Our ref: St Aloysius College - Rozelle Campus (SSD-27208140)

27 May 2022

Subject: **Request for additional information- St Aloysius College - Rozelle Campus (SSD-27208140)**

Figure 12: Pick Up and Drop Off Location

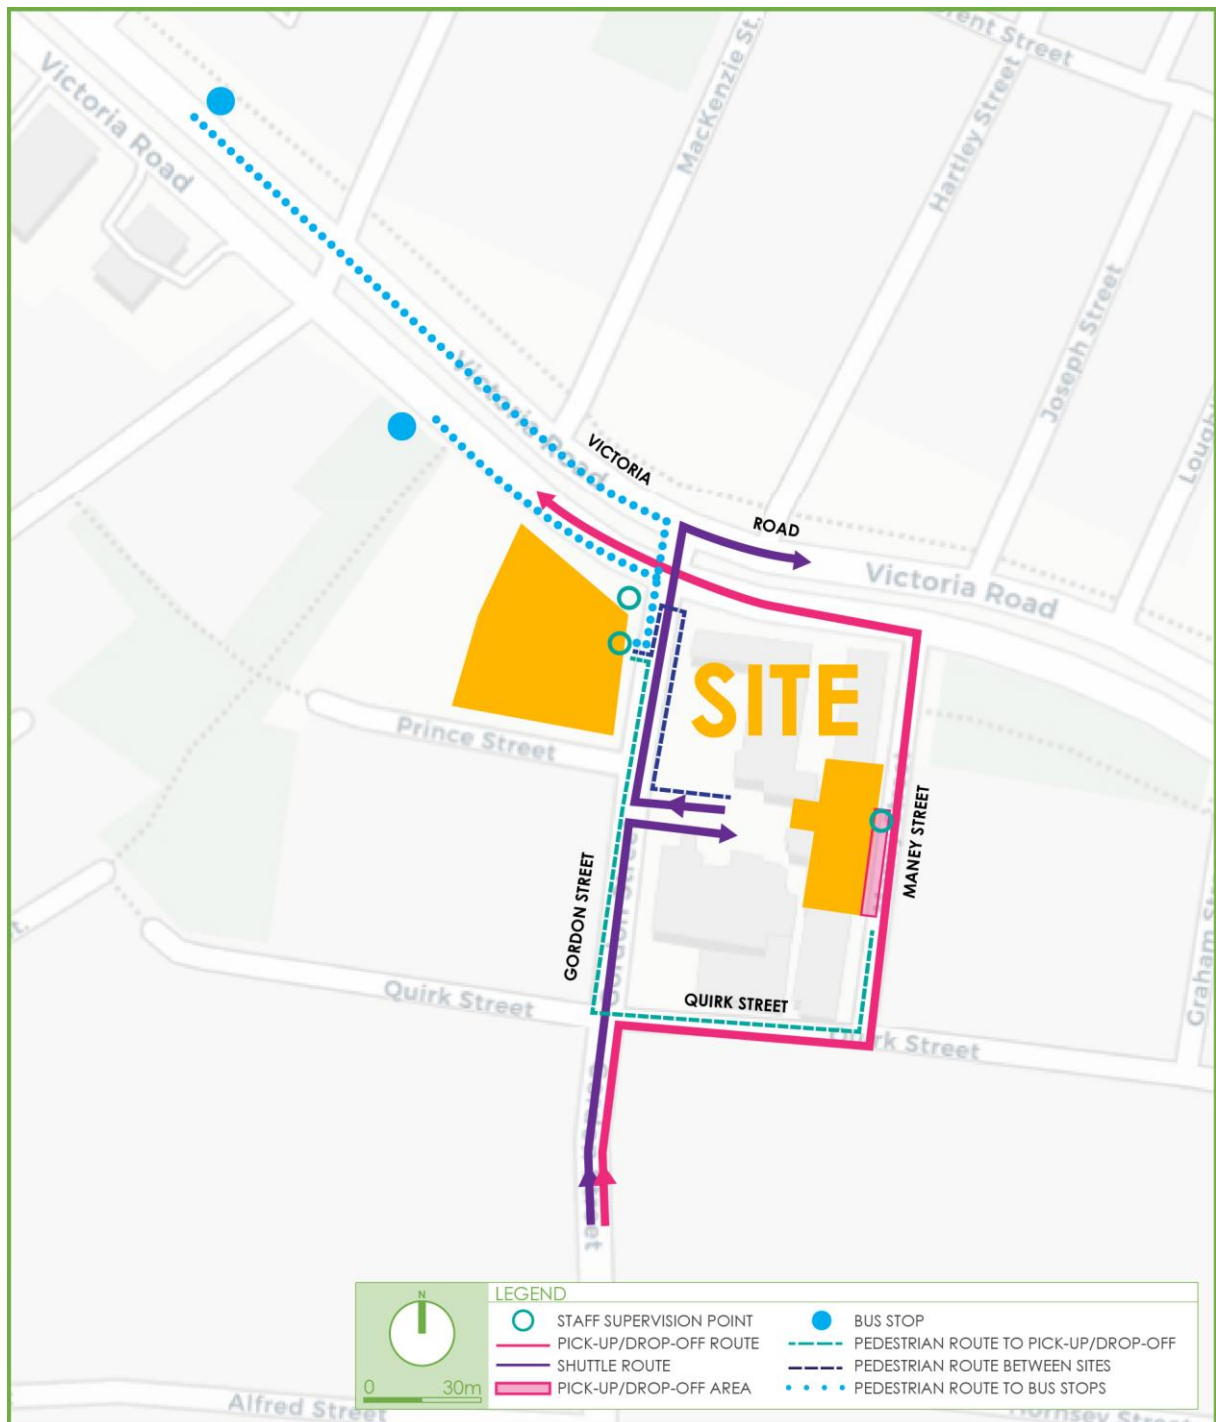
1. Inner West Council (Council) has reviewed the RtS and raised concerns regarding the inadequacies of the drop-off/pick-up zone (DOPU), the shuttle bus swept paths and on-site parking demand. Council's comments to the RtS are attached to this letter (**Attachment A**). The Department agrees with the concerns raised by Council and requires you to address all of these matters comprehensively.

5. The RtS states that many alternative locations have been considered for the DOPU. The amended TAIA is required to include the consideration of the other DOPU alternatives and provide the evaluation of each option separately, to establish that Maney Street is the only available option for use as a DOPU.
6. Please provide a table listing all the proposed plans.

Figure 16: Arrival and Departure Routes for vehicles and pedestrians

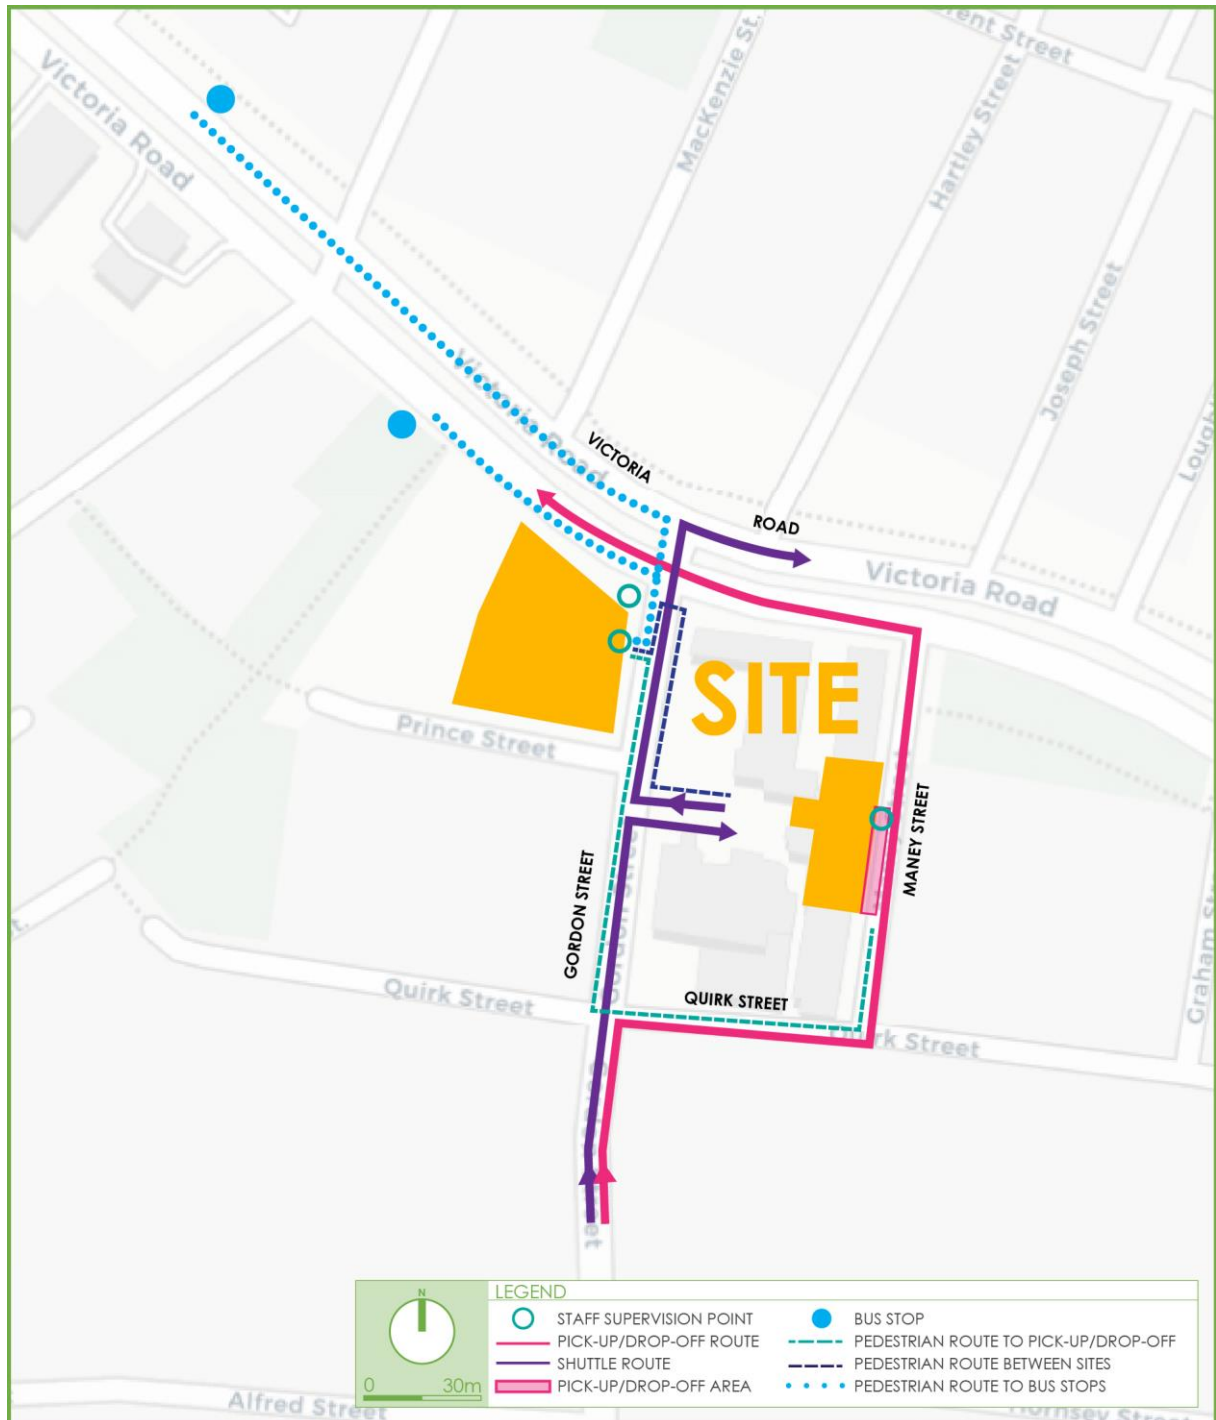
4. According to TAIA, the existing width of the pedestrian footpaths along Maney Street and Quirk Street are 1.3 and 1.5 meters (m), respectively. These footpaths are proposed to be used as part of the walking route from DOPU to the school site. It is proposed that a staff member will supervise and marsh students during the pick-up and drop-off time. The amended TAIA is

required to assess and confirm the suitability of these pedestrian footpaths to service eight students and one staff safely.

Car Park Mark Up p

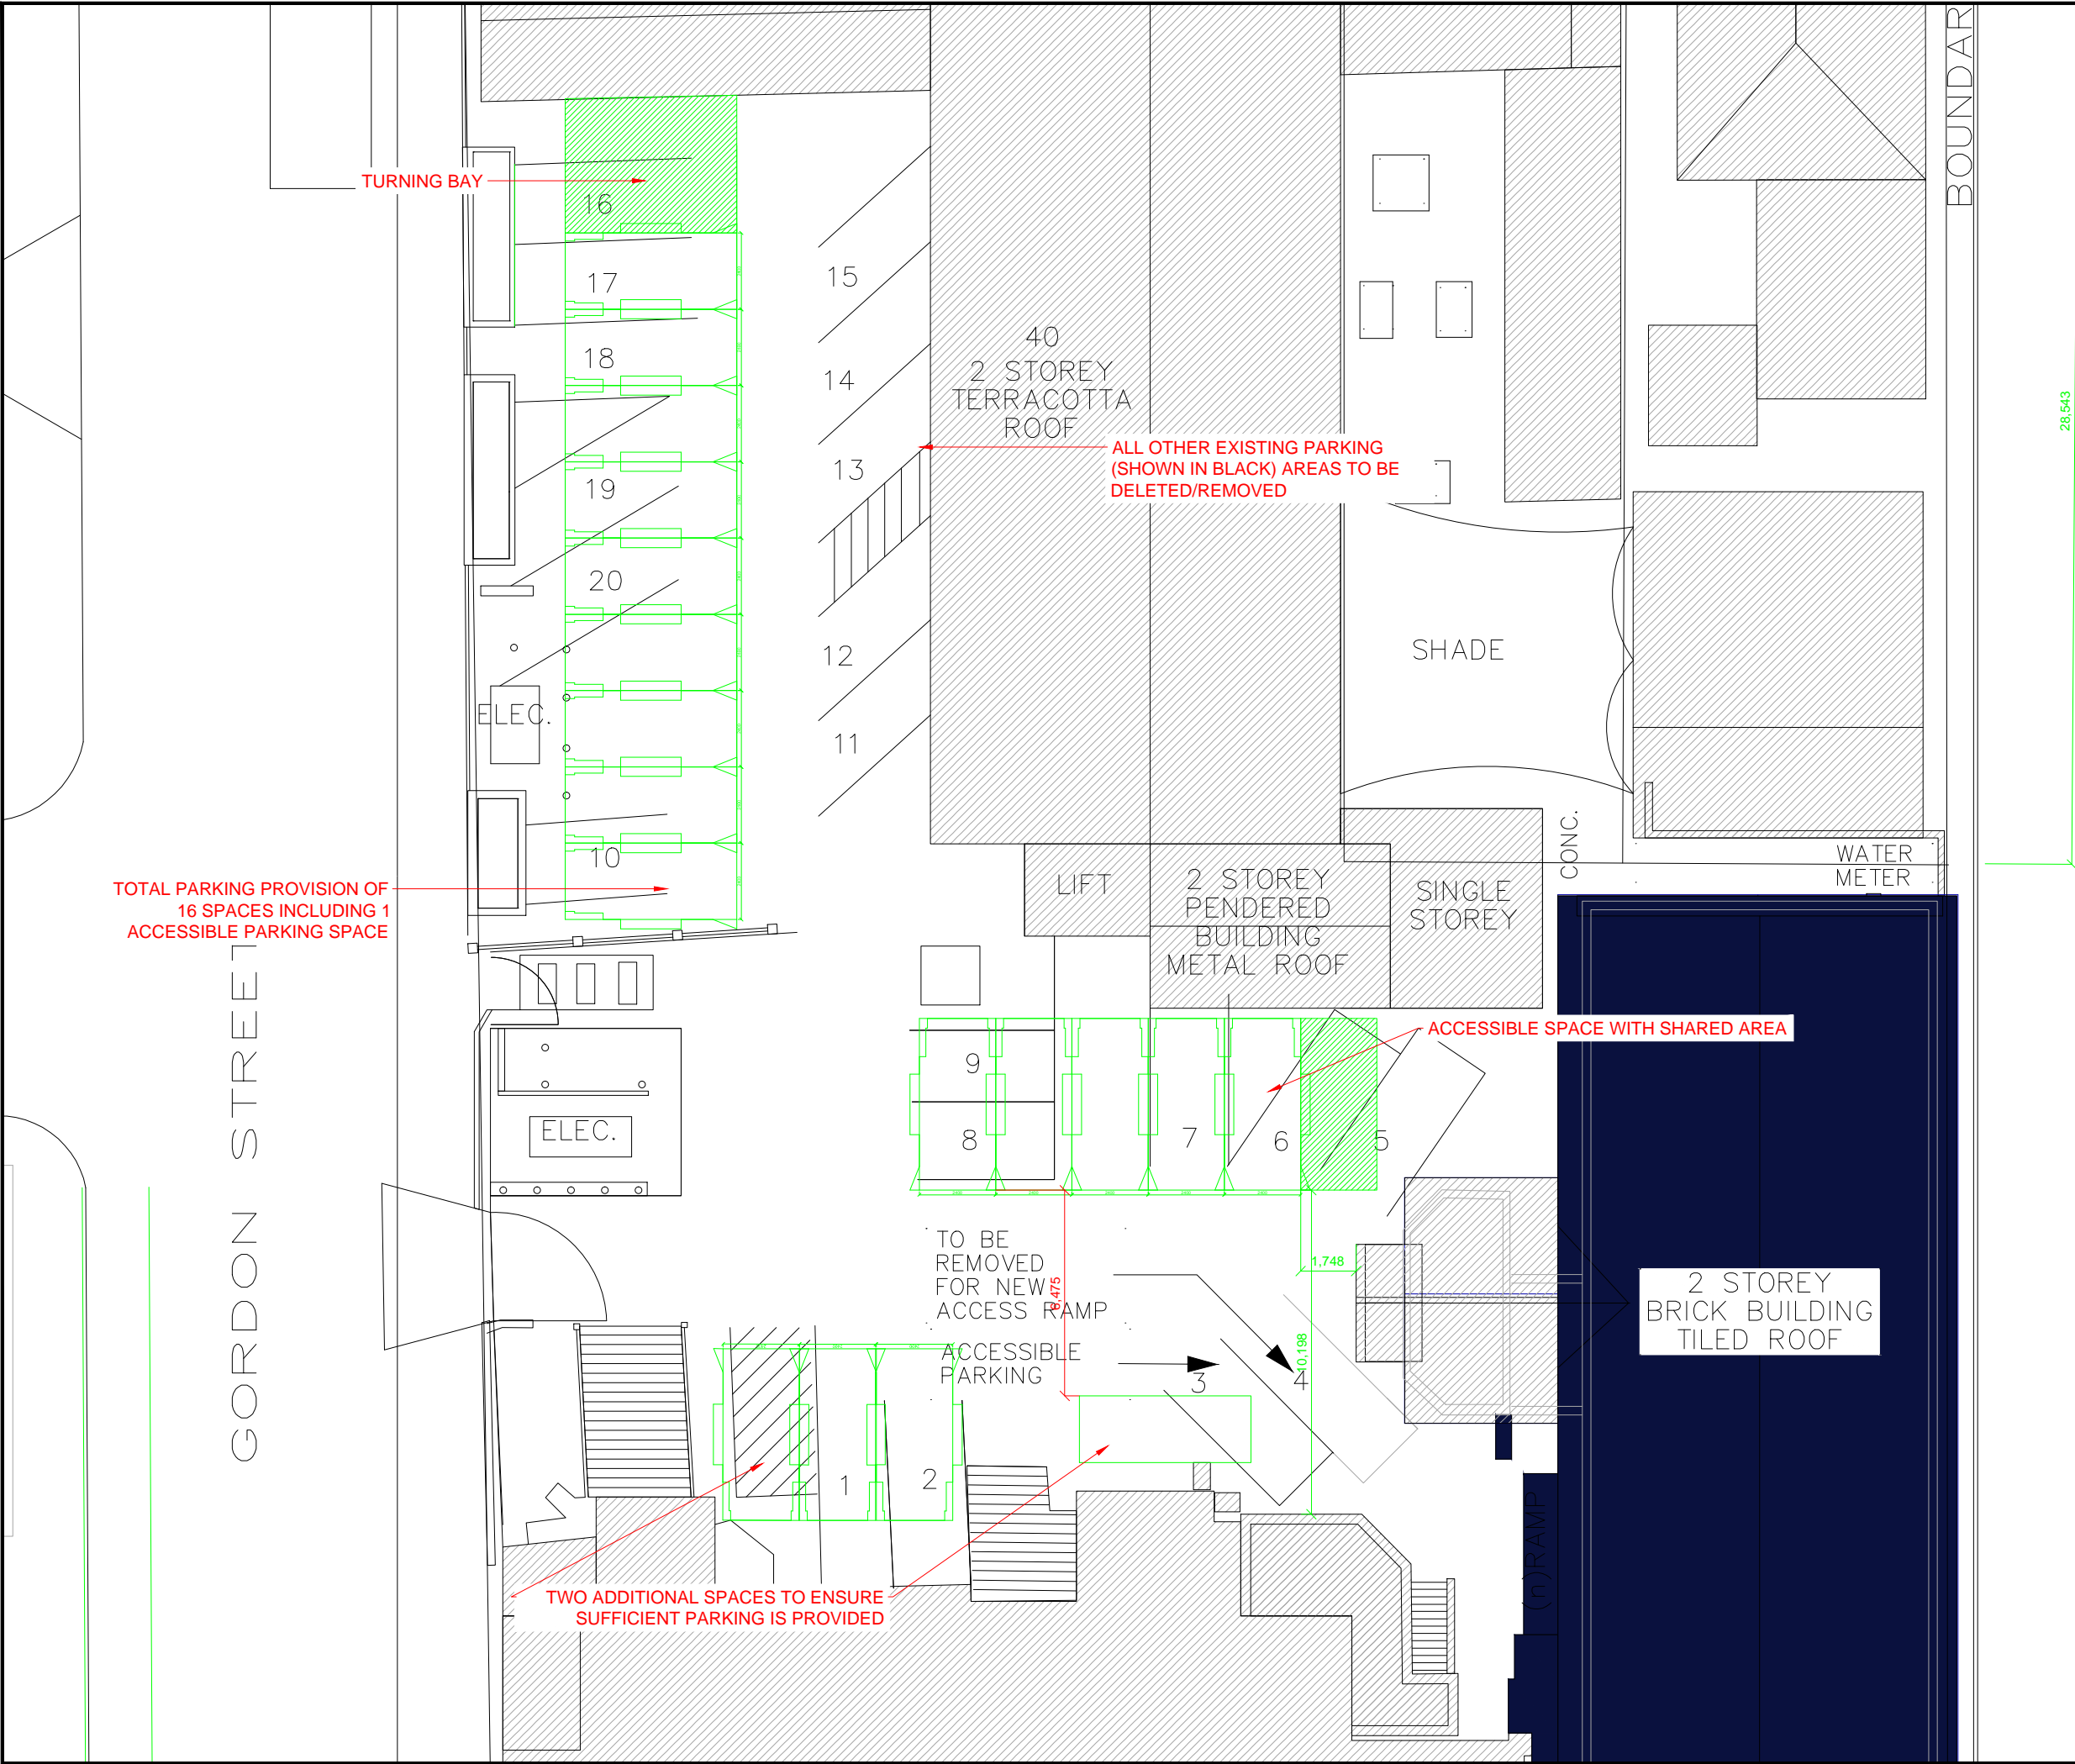
3. The Department notes that the submitted Transport and Accessibility Impact Assessment (TAIA) incorrectly assumes that there are 19 car spaces available within 2A-2B Gordon Street, whereas there are only 16 spaces car parking available. This means that only one car space would be allocated to the school, when Sydney Community College is in operation (Monday to Friday) and uses 15 car spaces. However, the TAIA indicates that 4 car spaces would be available for the school. Additionally, the TAIA also states that 1 – 2 car spaces would be available for the theatre use on weekday mornings.

The number of car spaces within the site (being 16) cannot cater for the three concurrent uses on a weekday, based on the above data. You are requested to clarify this issue and provide suitable evidence of negotiations and/or agreements that would be in place to ensure that sufficient car parking is available for each of the uses during a typical weekday.
